June 2, 2026

**RE: Flying Horse North Filing 9 / Traffic Generation Analysis
El Paso County, Colorado**

PCD File No: PUDSP263

PROP. FILING 9
(11 LOTS)

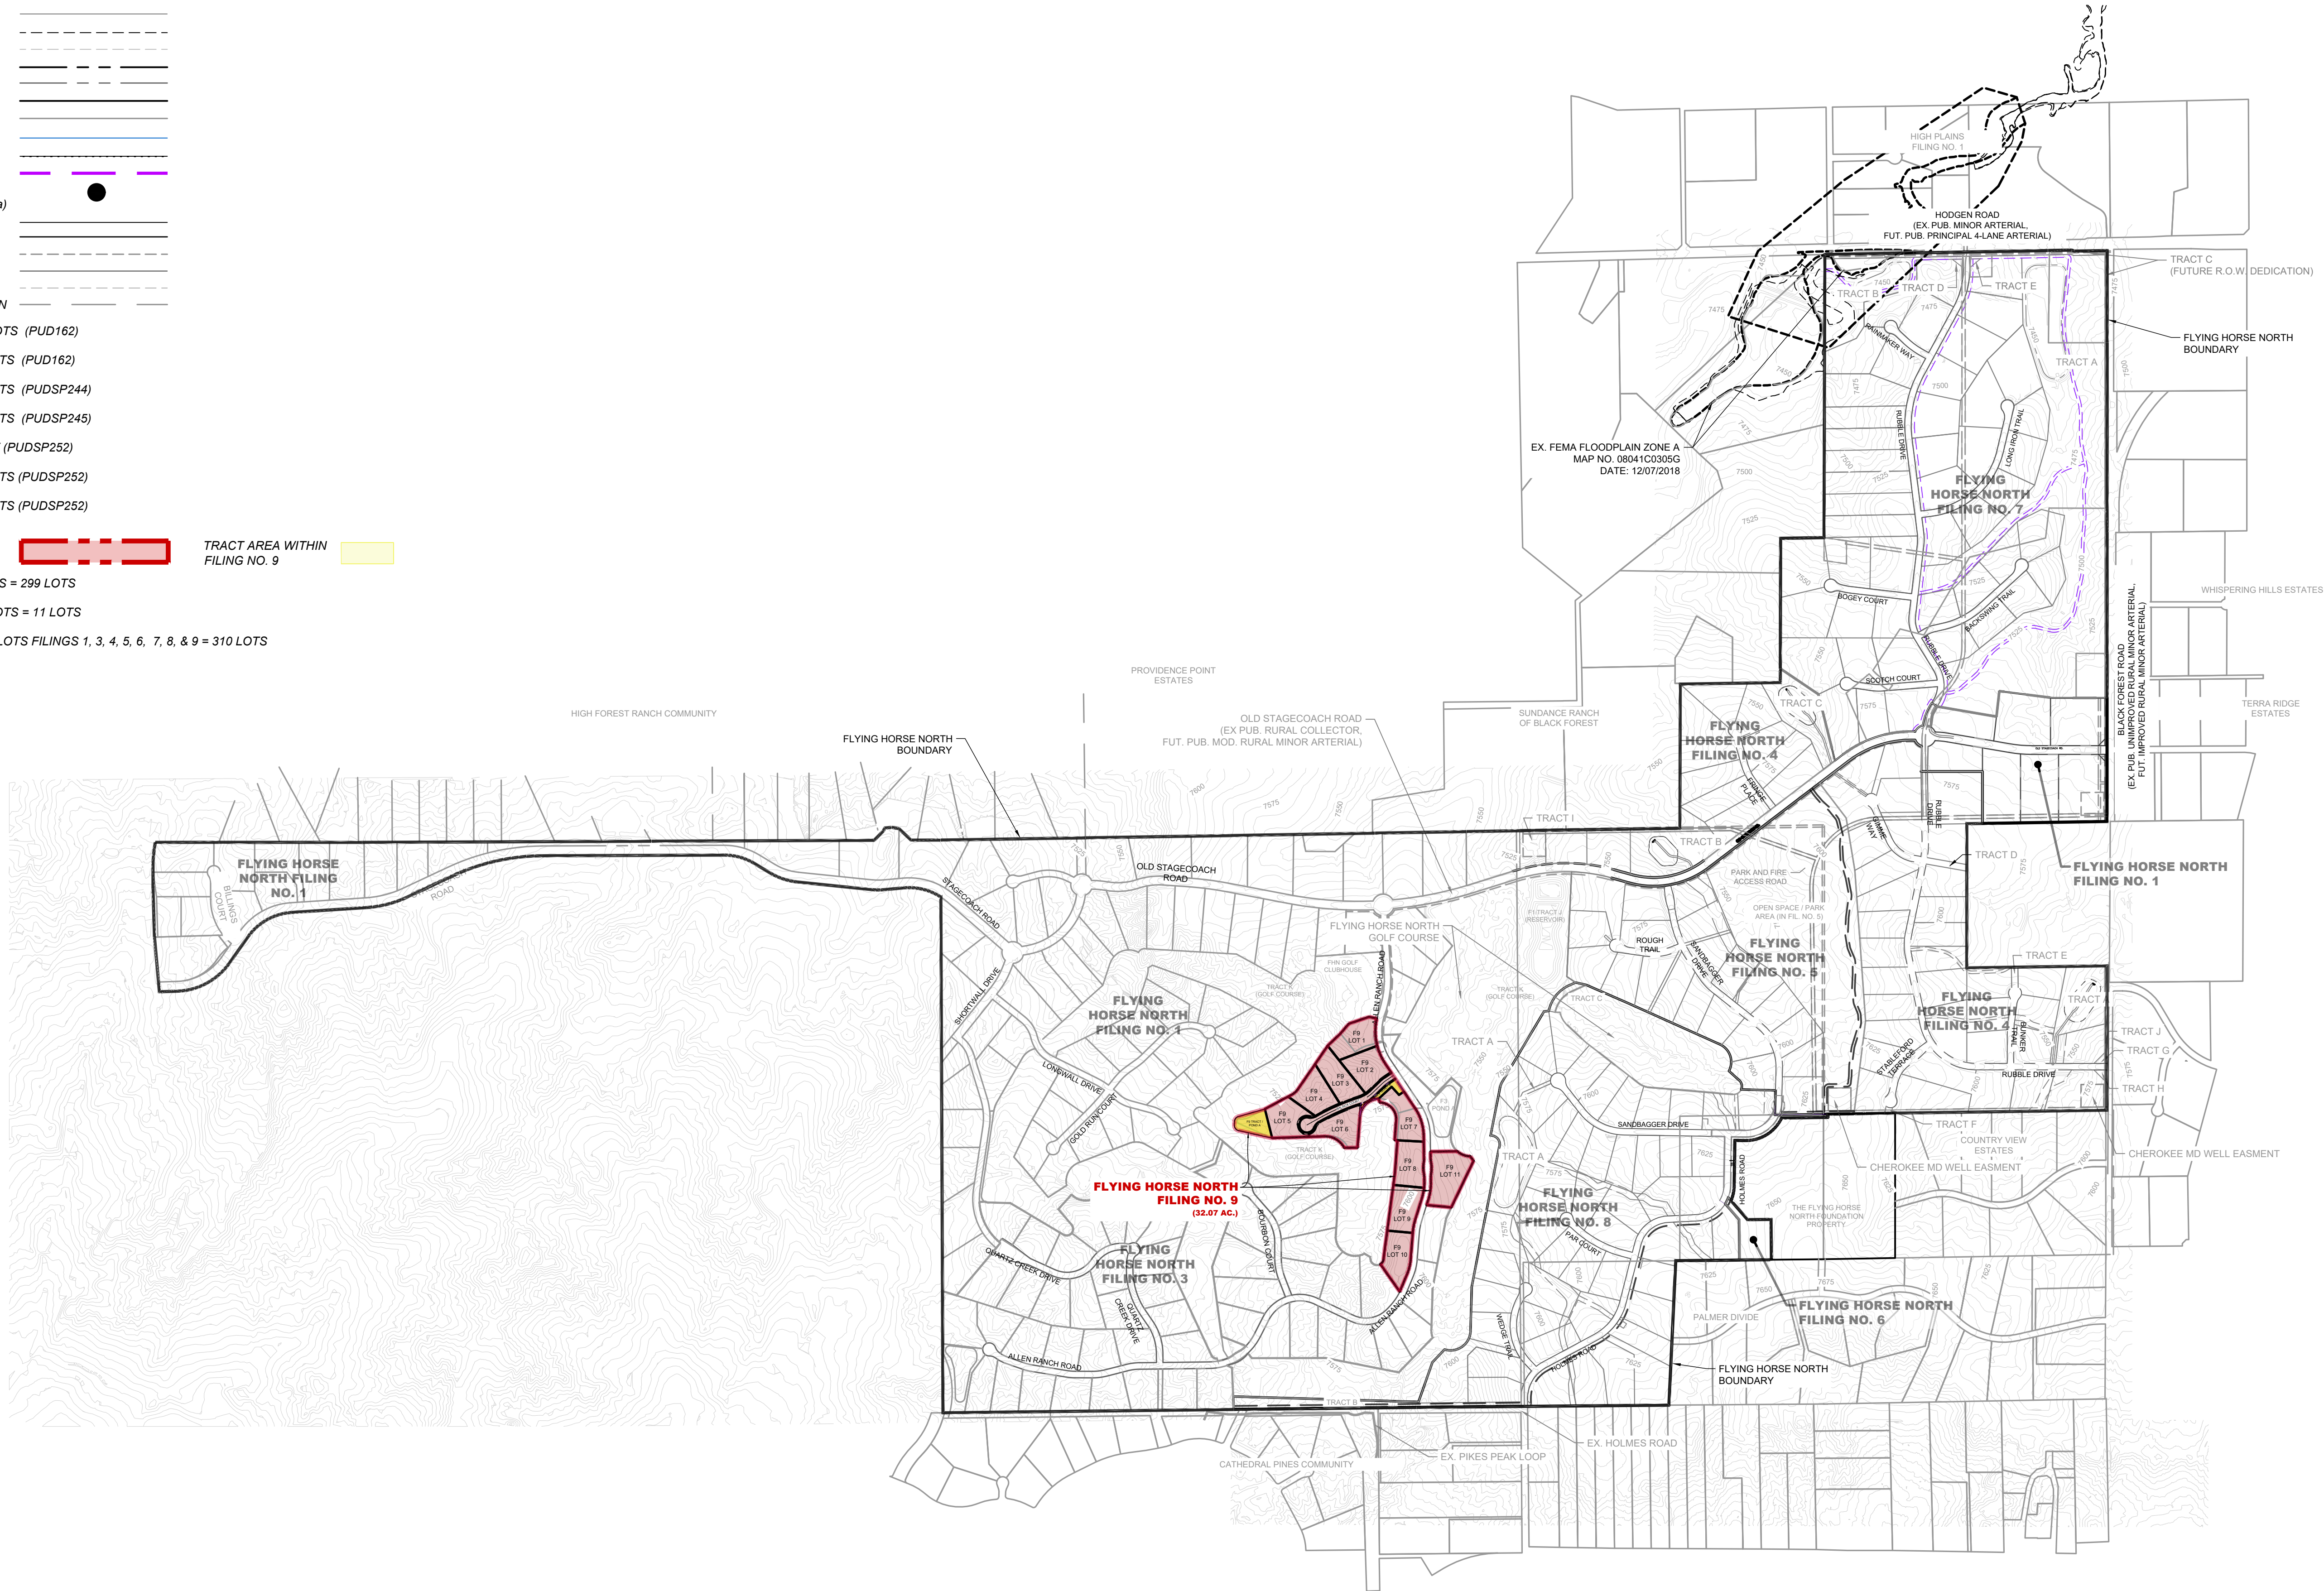
please list the project number, PUDSP252 does not appear to include this area
